Modification of Development Consent

Section 4.55(2) of the *Environmental Planning and Assessment Act 1979*

Development consent: SSD 9874 granted by the Independent Planning Commission on 27 November 2020

Modification: Increase in solar panel height

APPENDIX 5: HEAVY VEHICLES REQUIRING ESCORT AND HEAVY VEHICLE ACCESS ROUTE RESTRICTIONS

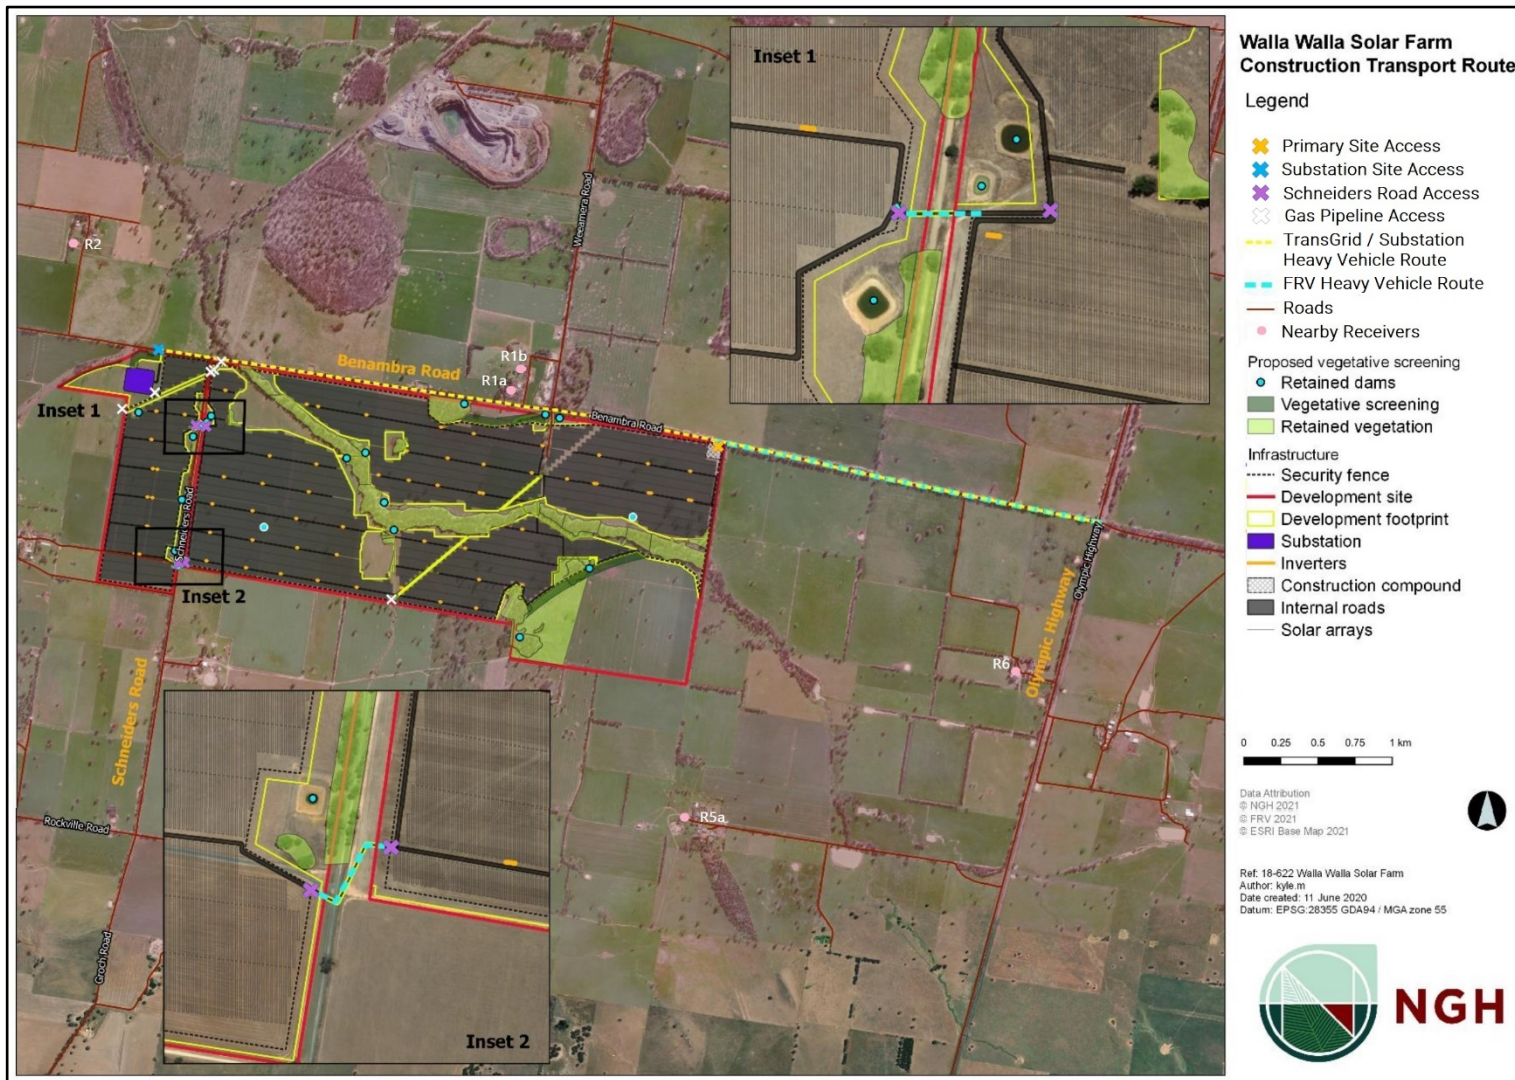
, or by 31 July 2022, whichever is the later;
7. In Appendix 5: Over-Dimensional and Heavy Vehicle Access Route Restrictions, replace the map with the following map:
